From: Laura Gibbons
Sent: 22 January 2019 11:33
To: Planning.Responses
Cc: Simon Davis
Subject: RE: Planning Consultation on: BE/137/18/PL

Engineers Comments Regarding Surface Water Drainage

Site Address: 2018
Rolls Royce Motor Cars Technology and Logistics Centre
Newlands Road Bersted

Description of Works: Temporary storage building & associated works

Proposed Site Layout Plan

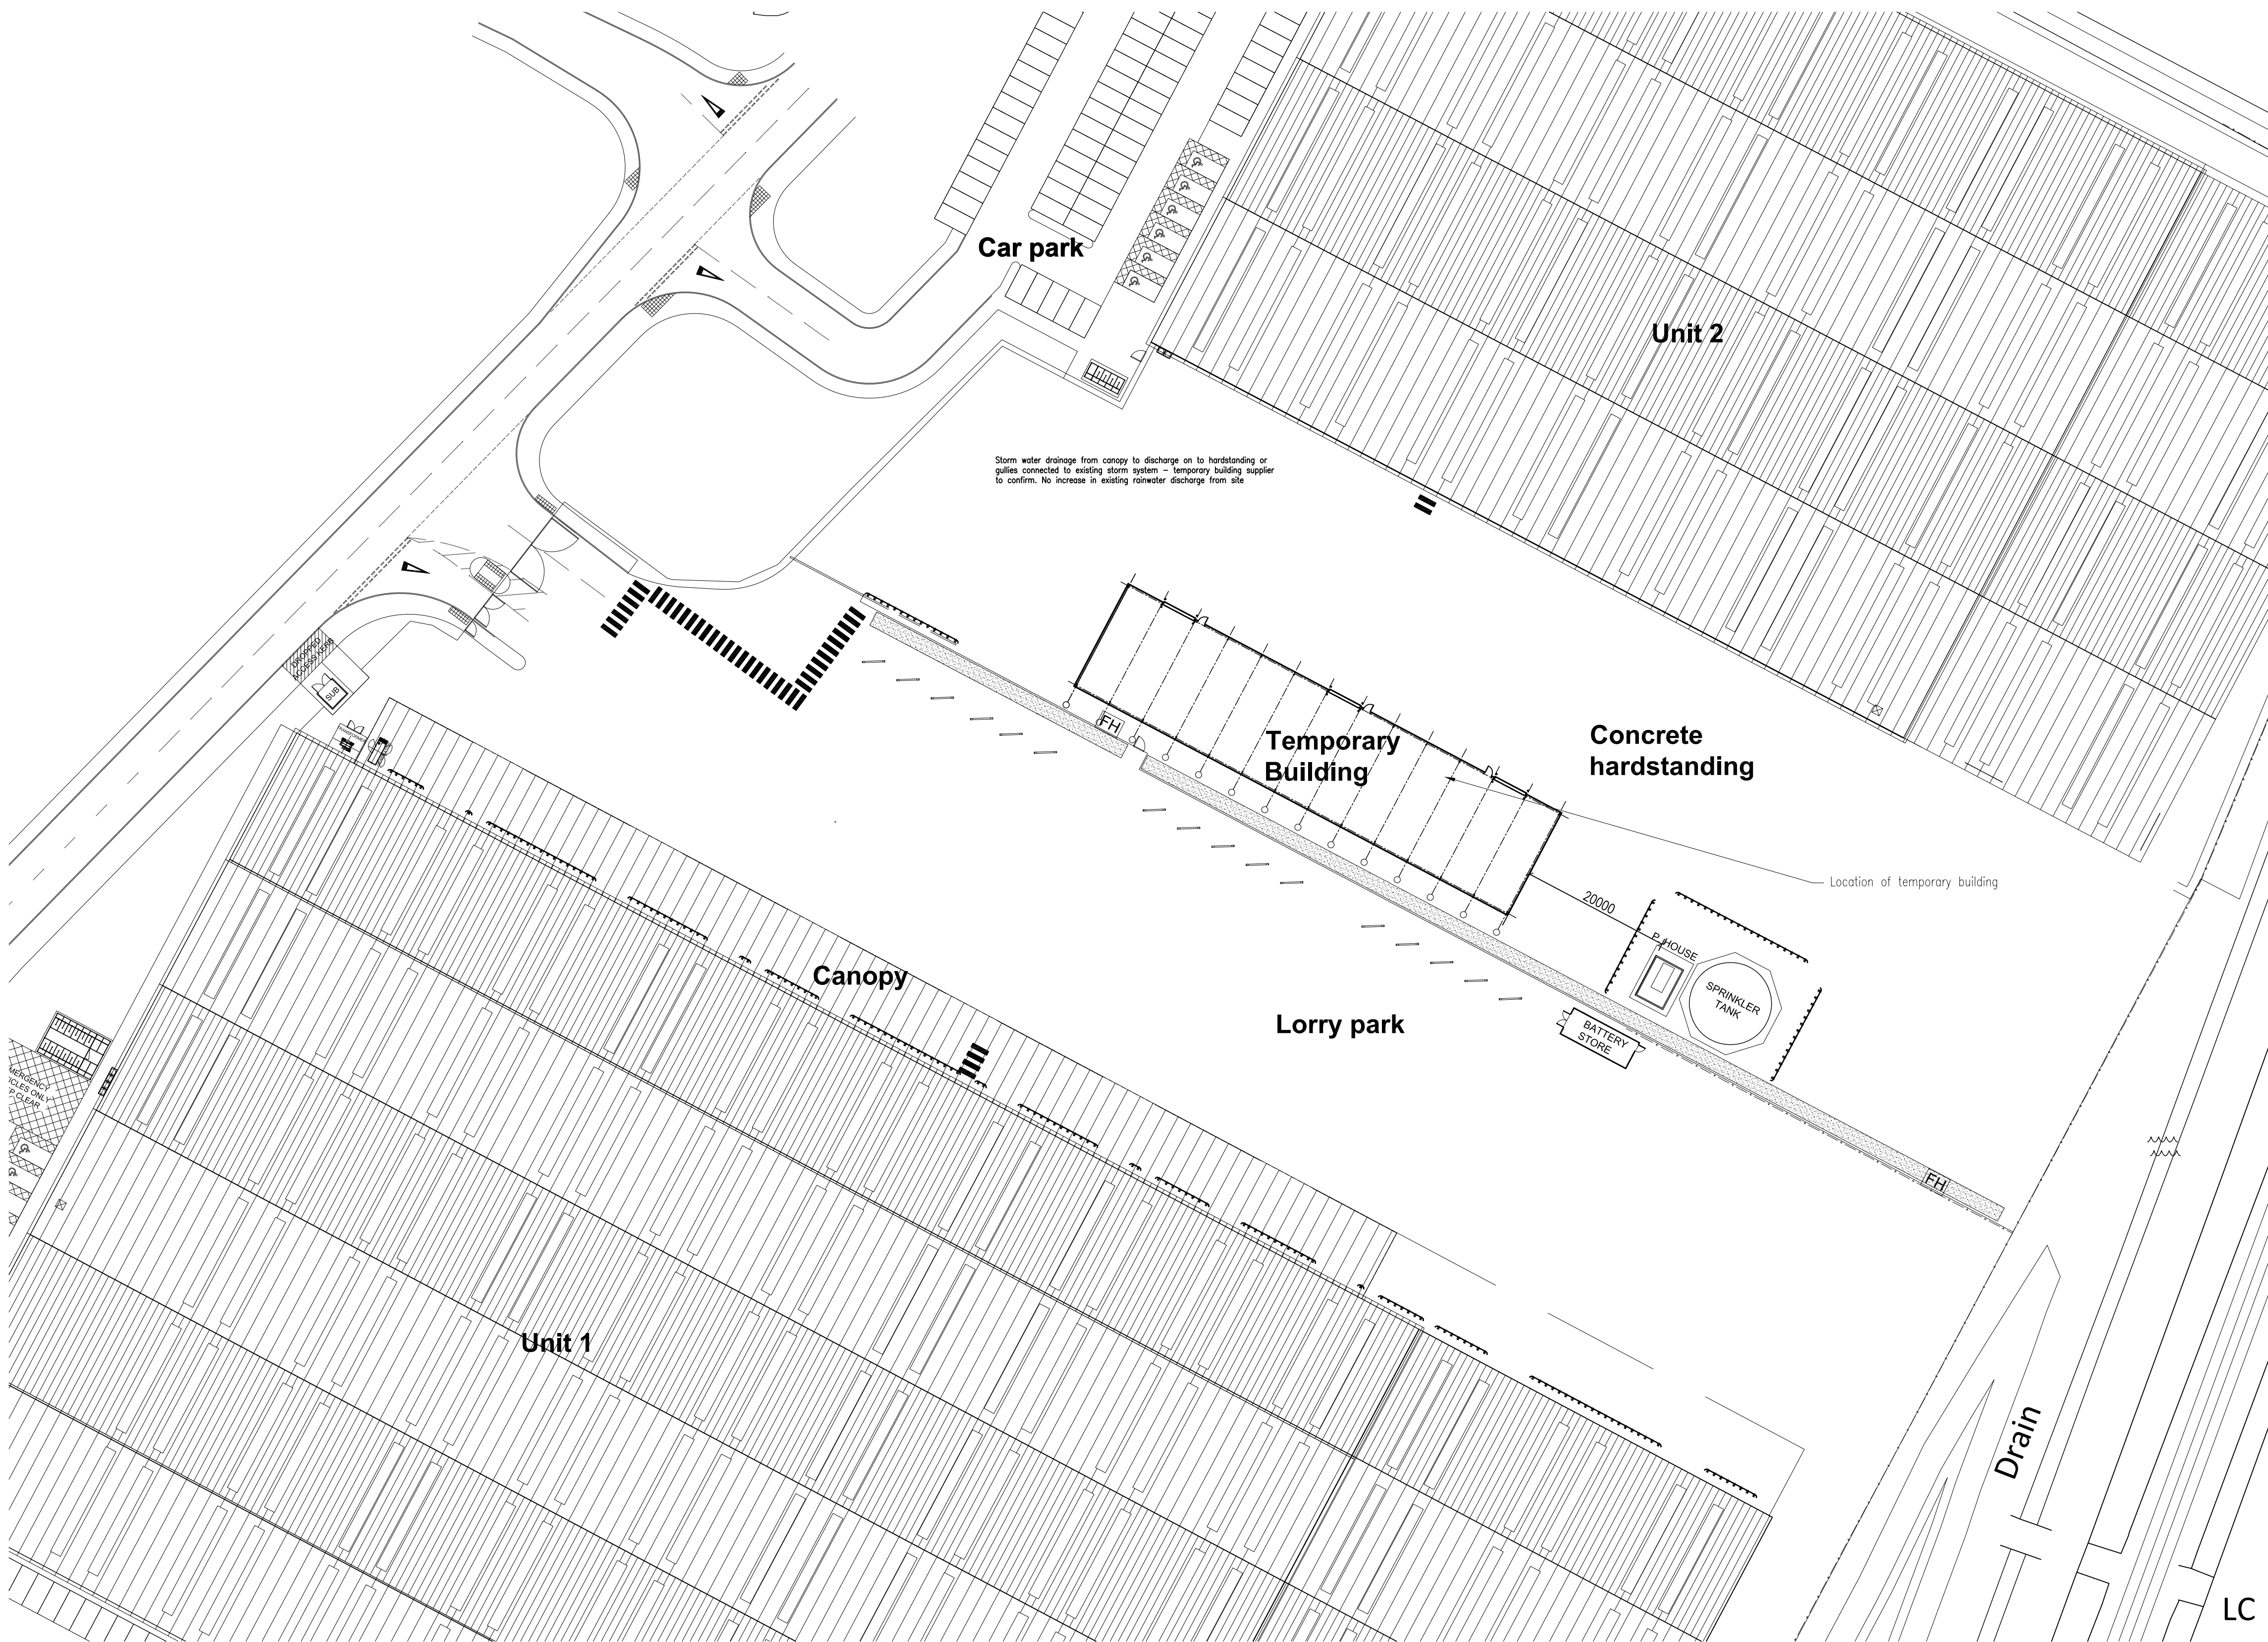
We require confirmation that the proposed temporary structure will not be located directly on top of the existing surface water drainage network. Please can the applicant provide as built survey of the surface water drainage network.
